**Re: Children's Grief Center
4125 Carlisle Blvd NE
Traffic Circulation Layout
Architect's Stamp NONE PROVIDE (G16-D157)**

Based upon the information provided in your submittal received 05-17-2021, the above referenced plan cannot be approved for Building Permit until the following comments are addressed:

B1 SITE PLAN
1" = 20'-0"

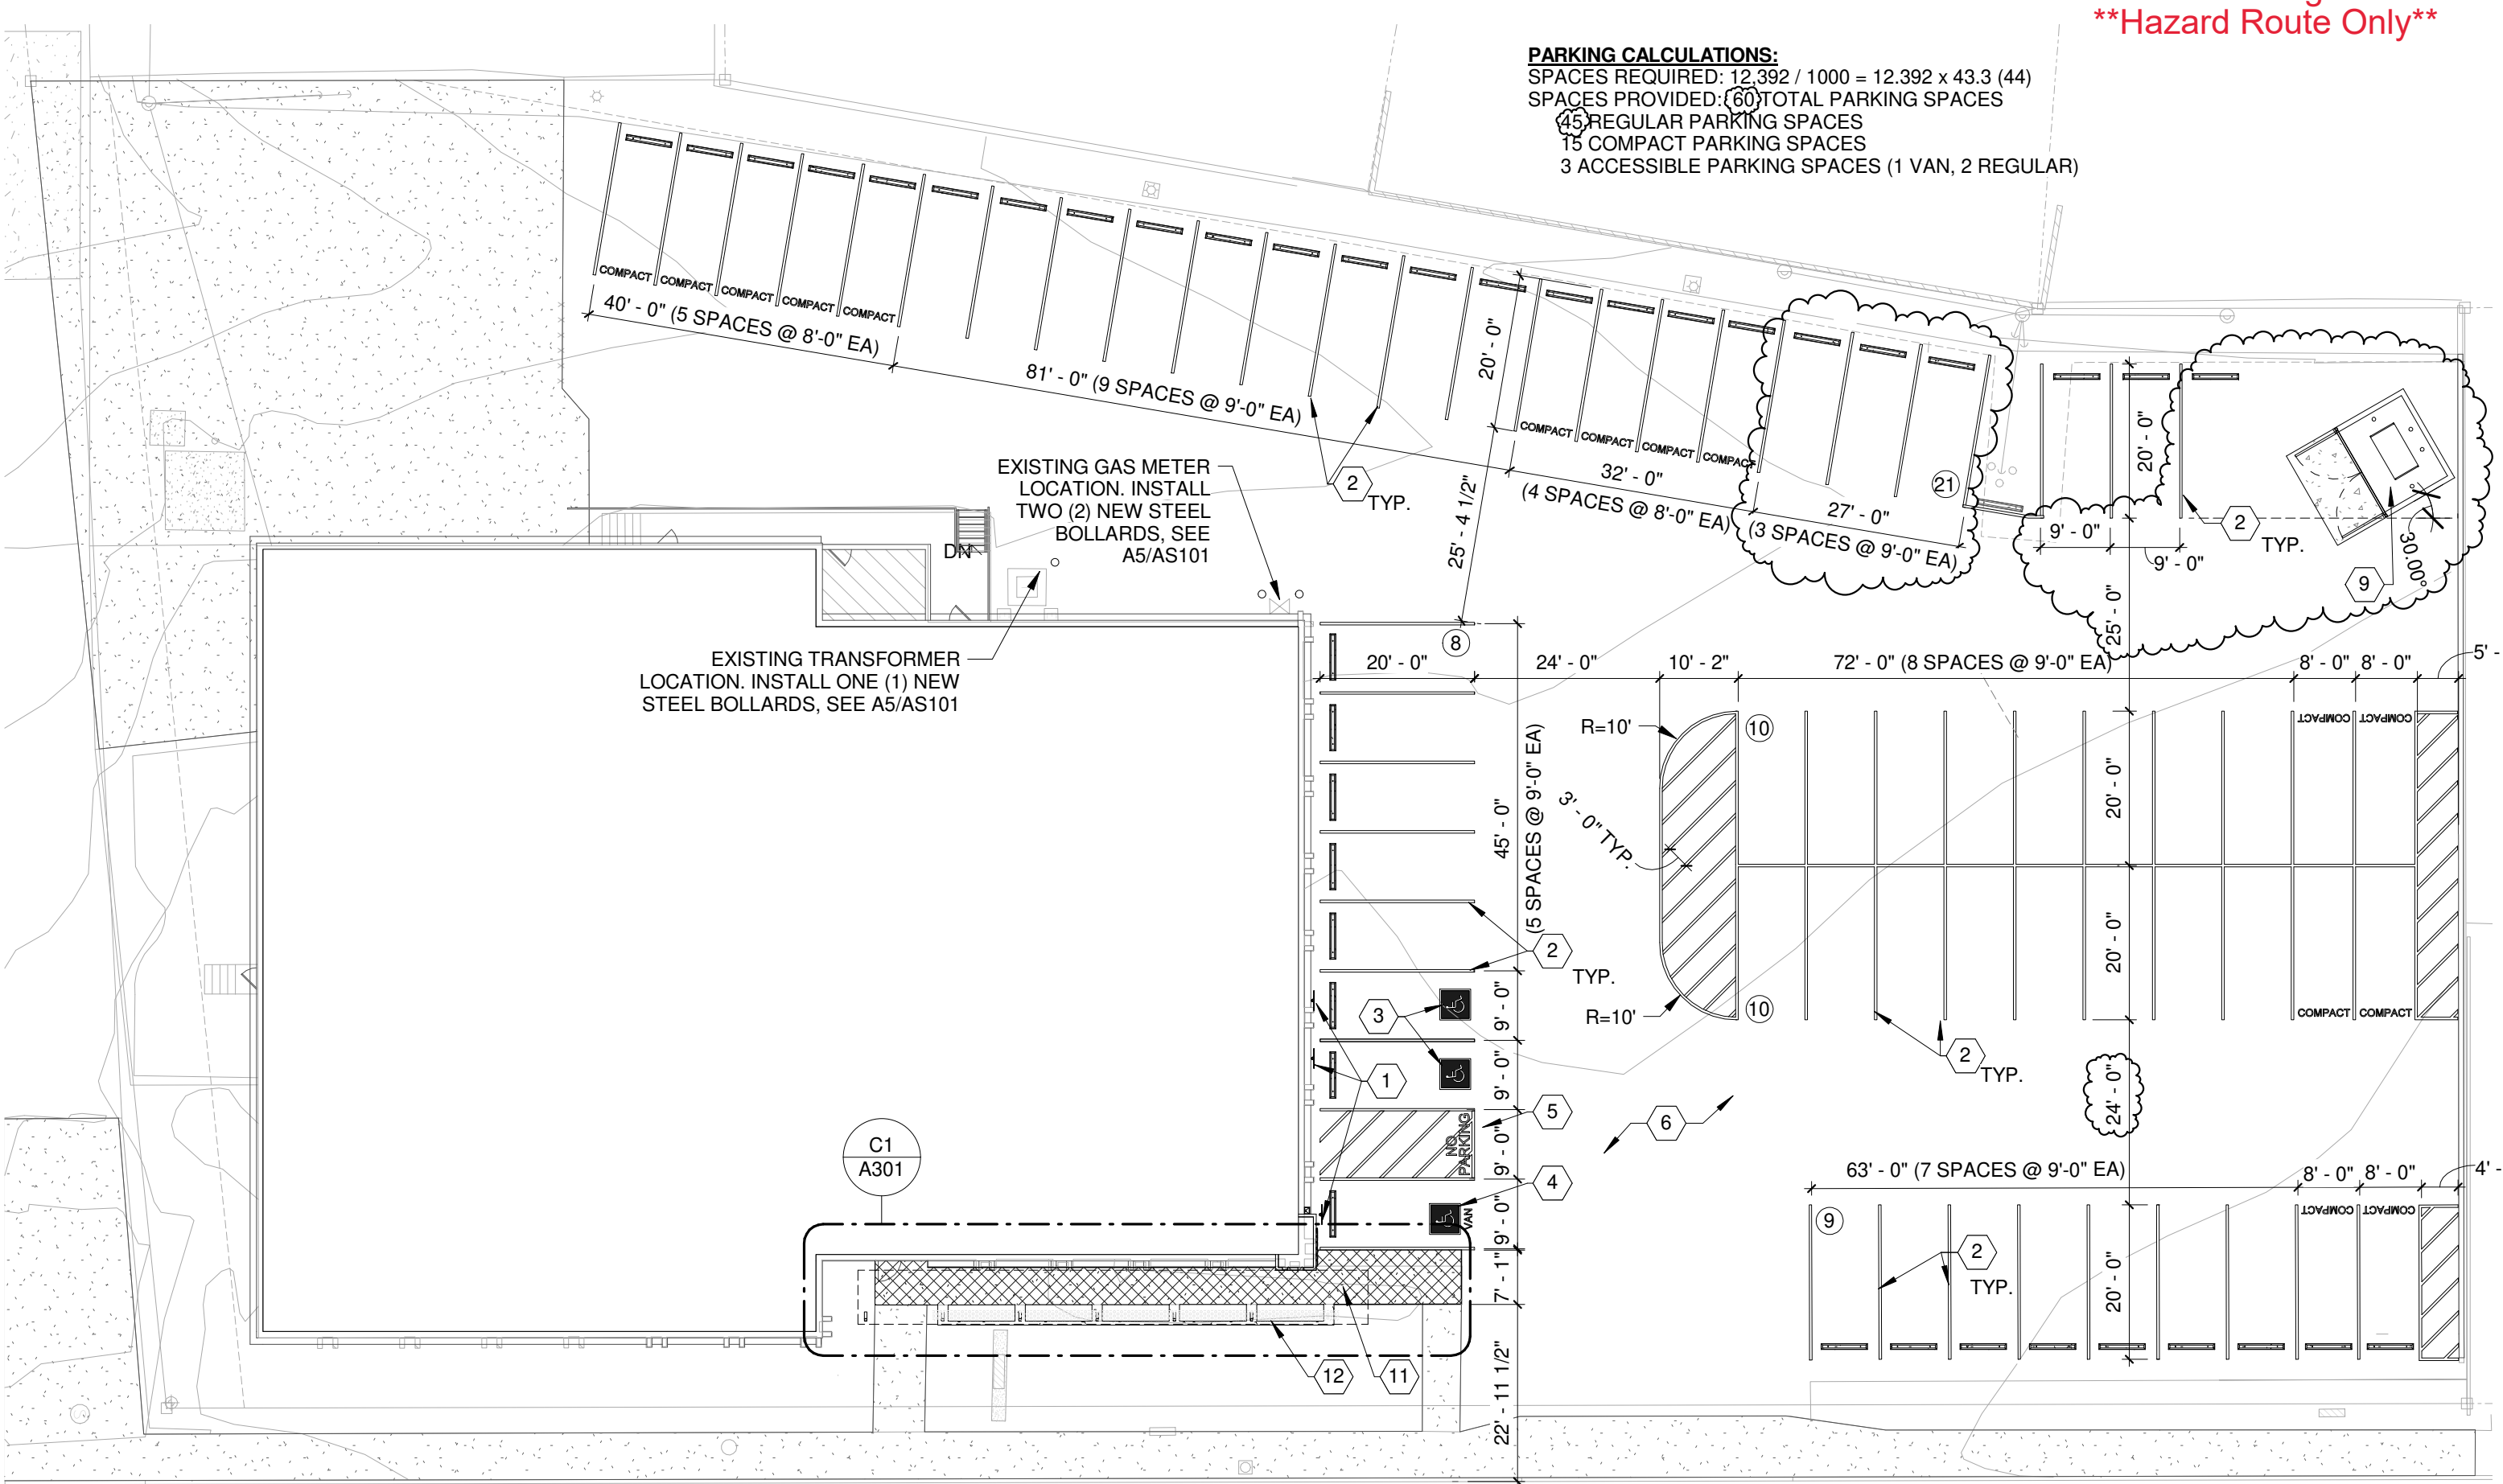
- PO Box 1293
Albuquerque
NM 87103
www.cabq.gov
1. West side of building: Please provide details (dimensions and detail of proposed striping).
 2. **Resubmitted Site Plan:** The traffic circulation layout must be stamped, signed, and dated architect licensed in the state of New Mexico. This has not been done for the Site Plan resubmittal.

3. Fire approval will be needed for proposed parking lot circulation.
 4. Per DPM, a 6 ft. wide ADA accessible pedestrian pathway is required from the ADA parking stall access aisles to the building entrances. **Please clearly show this pathway and provide details.(dimensions and notes defining the pathway).**
